**KIRKLEES METROPOLITAN COUNCIL
INVESTMENT & REGENERATION SERVICE**

DELEGATED DECISION TO DETERMINE PLANNING APPLICATIONS

Reference No: 2020/62/93746/W

Description: Erection of single storey extension to outbuilding with associated works to create dwelling forming annex accommodation associated with Holmdene, Oastler Grove, Mirfield, WF14 0JB (Listed Building)

PROPOSED BLOCK PLAN
1:500

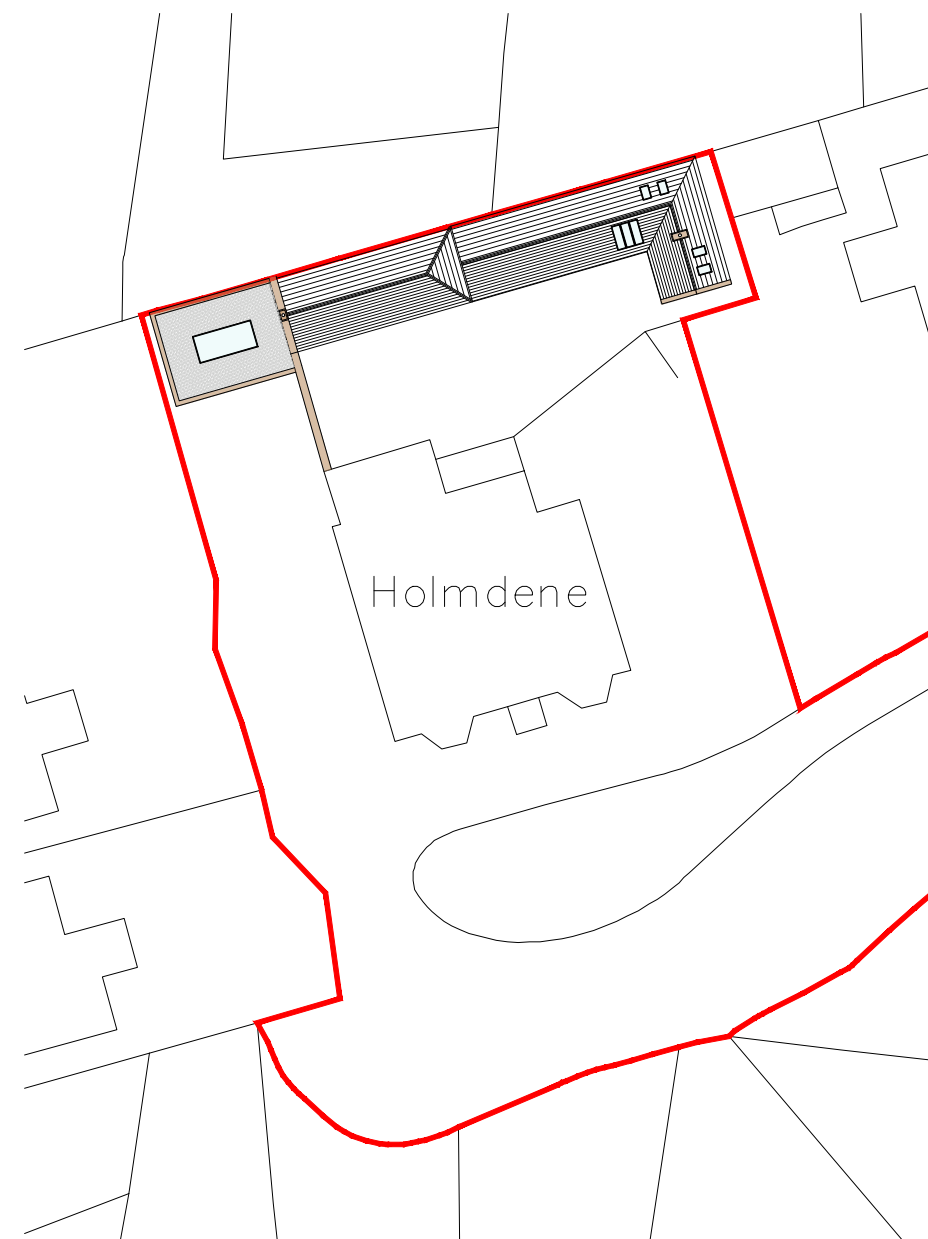
40a and 42 Lee Green are a detached bungalow and a two-storey detached house, respectively. Both are set within spacious plots of land to the north of the application site. The existing outbuilding is directly adjacent to the boundary of no.40a. The proposal for a single-storey flat roof extension to this building would not harm the residential amenity of these neighbours because it would not be as high as the existing building. In addition, there is a separation distance of approximately 42.6m between this extension and no.40a. This is considered adequate to reduce the potential of overshadowing and overbearing impacts upon the residents concerned. If this development is recommended for approval, a condition could be imposed to restrict new openings being created in the rear elevation of the extension. This would assist in protecting the privacy of the neighbours.

The “L” shape extension would be next to the southern boundary of 42 Lee Green. This extension would be no higher than the existing outbuilding. Whilst the potential of impact resulting from the siting of this extension is noted, officers consider, for the reasons given in relation to no.40a, that there is unlikely to be substantial harm to the living conditions of the occupiers of no.42.

To the east of the application site is a two-storey detached house, known as 3 Oastler Grove. This house already has a substantial outbuilding adjacent to the site boundary. As such, although the development proposed would be very close to the shared boundary, it would not unduly prejudice the living conditions of the occupiers of this adjoining house. The residents concerned would continue to enjoy an open outlook from their rear facing windows and gardens. They would still benefit from appropriate levels of daylight and sunlight.

The proposal would bring the curtilage building closer to the boundary of 3 Redwing Park, through the erection of a flat roof extension. Since the extension would be limited to single storey in height, it would not appear overly imposing from the windows and gardens of this adjoining house. In addition, there would be appropriate spacing between this house and the extension, to avoid harm to residential amenity.

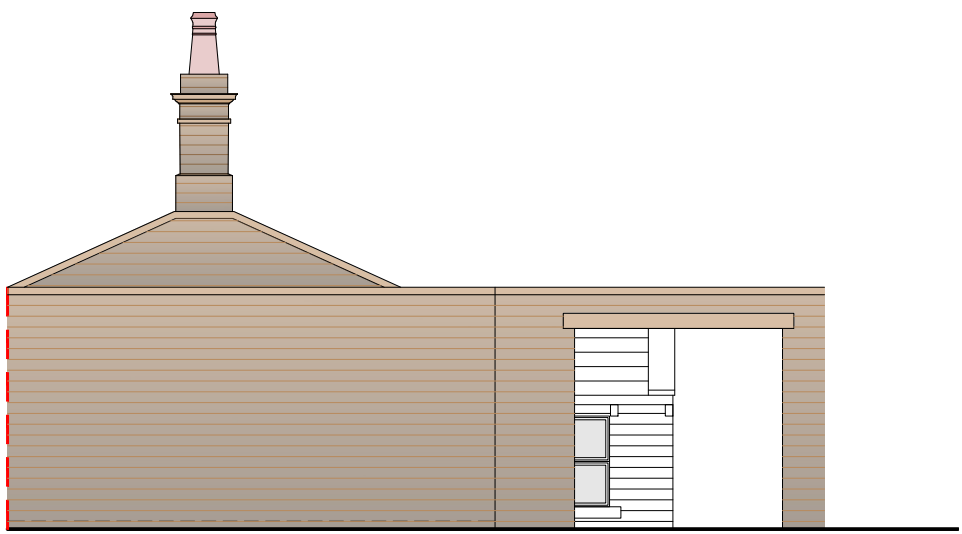
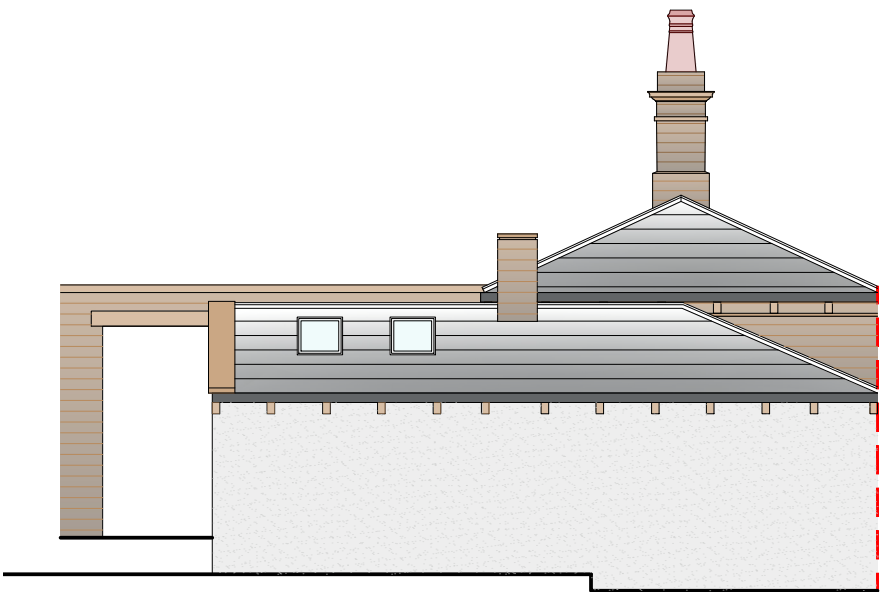
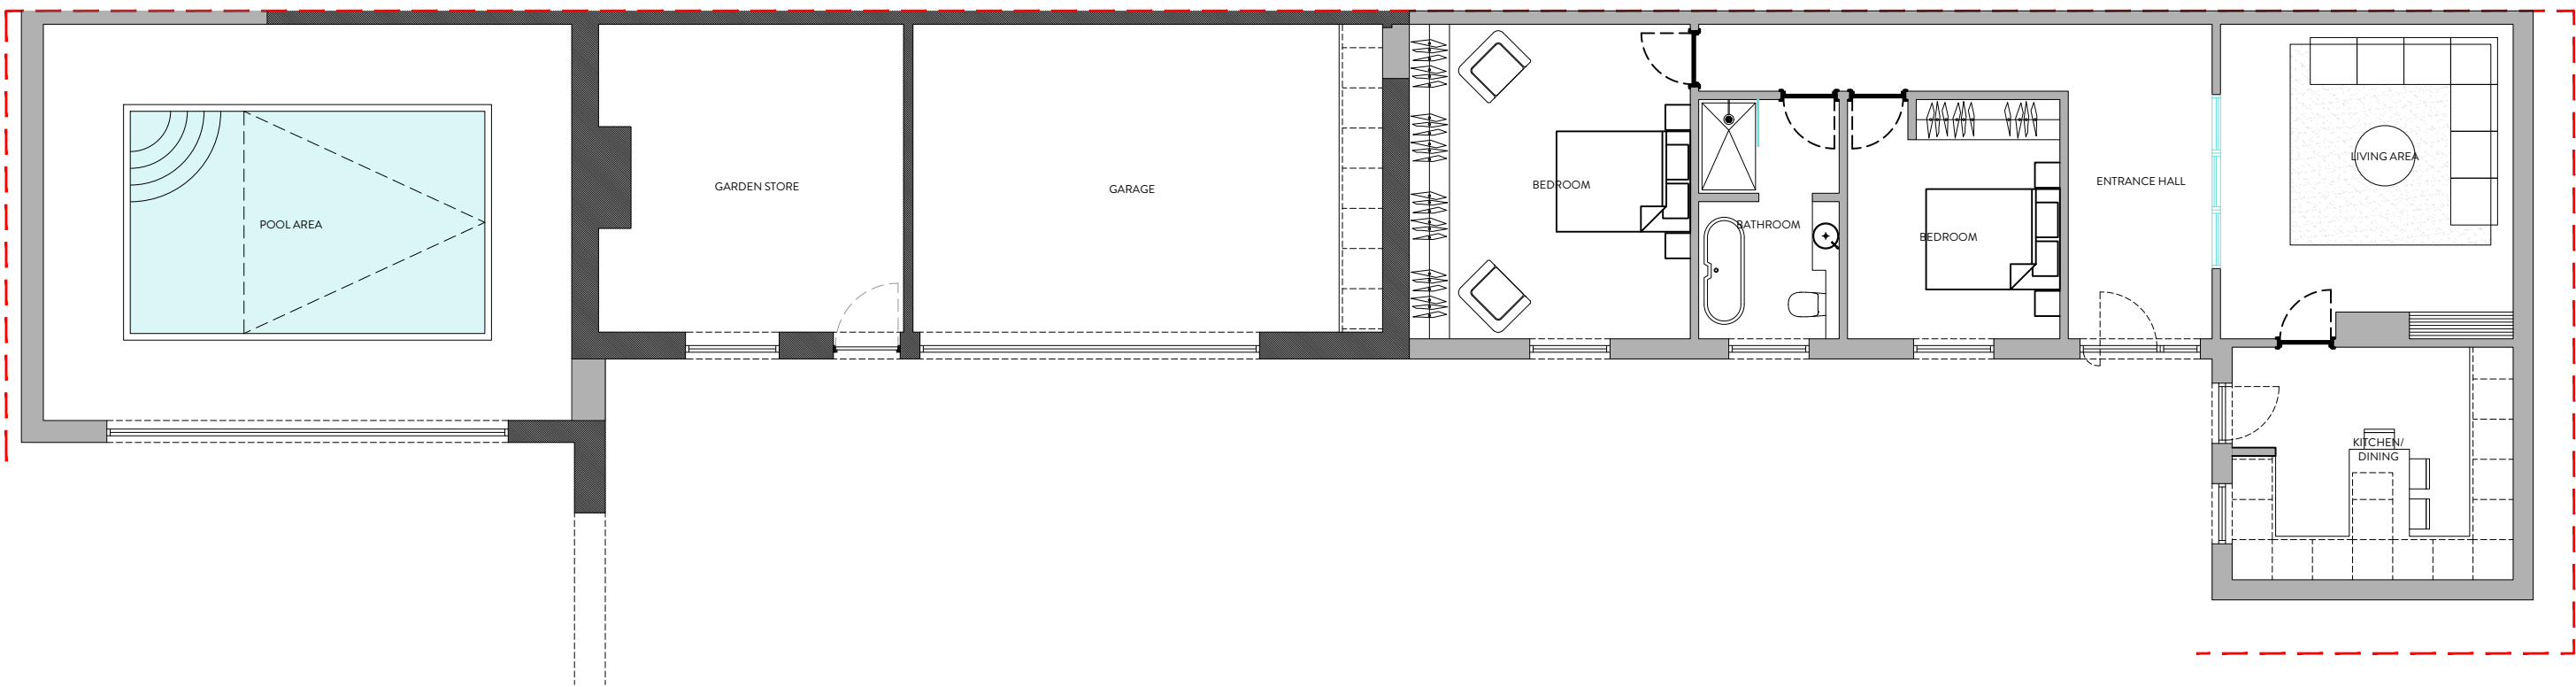
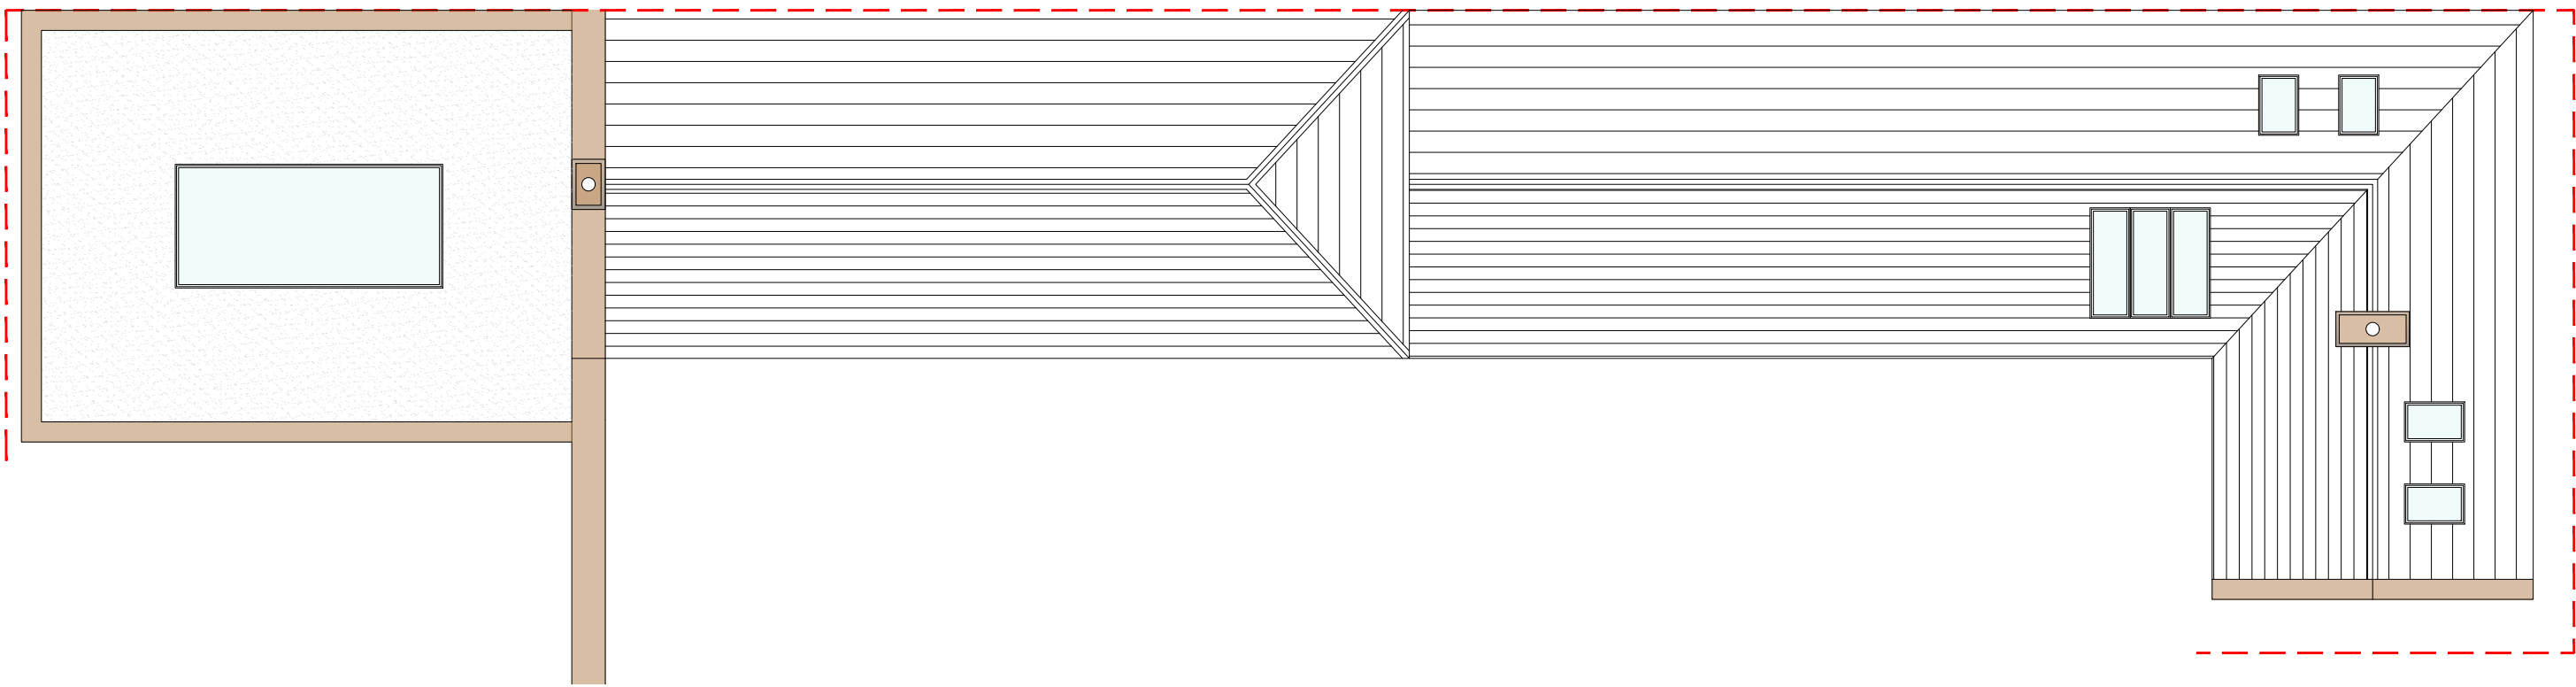
In this case, the applicant seeks to demolish the stores on either side of the outbuilding and to erect a flat roof extension to the west and a dual pitched roof “L” shaped extension to the east. In addition, the double garage would be enlarged with the two garage doors replaced by one larger garage door. The

scale of development is not acceptable from visual amenity and heritage conservation perspectives.

As a curtilage listed building that historically served Holmdene and still serves it to the present day, this building contributes to the significance of the site by showing how the occupants lived, the status of the main house, and the architectural interest of the outbuilding itself. The proposal, if permitted, would introduce a hipped roof projecting element with a large garage door prominently visible in the front elevation of the curtilage listed building. It would relate poorly to the traditionally designed frontage of the building and would result in the loss of the existing detailing and stone door surrounds.

In addition, the erection of substantial extensions on both sides of the building would change its built form to an extent that it would no longer appear as being subservient and sympathetic to the host listed building and the curtilage listed building. The visual balance of the outbuilding would be also distorted. In view of these considerations, officers consider the proposed demolition, alteration, and extension would give rise to less than substantial harm to the significance of the designated heritage asset.

Indeed, the residential annex would be accommodated entirely by the “L” shaped dual pitched roof extension rather than the existing curtilage building. As such, the development in question does not, in any way, assist in securing an optimum viable use for this building. Based on the information provided in this application, officers find there are no public benefits that can outweigh the less than harm arising from this development. Consequently, the proposal could not be supported in relation to policy LP35 of the KLP and chapter 16 of the NPPF. Further to the heritage considerations, there are also significant concerns about the scale and design of this development and its resultant impact on visual amenity and the local character.

1. The proposed development by reason of its scale, design and appearance would fail to preserve the traditionally designed frontage of the curtilage listed building, resulting in the creation of an incongruous built form that would be out of keeping with the host and curtilage listed buildings and would fail to establish a subservient relationship with these buildings. In addition, there are no public benefits to outweigh the less than substantial harm arising from this development. Therefore, to permit the development in its current form would give rise to significant conflicts with Policies LP24 and LP35 of the Kirklees Local Plan and Chapters 12 and 16 of the National Planning Policy Framework.
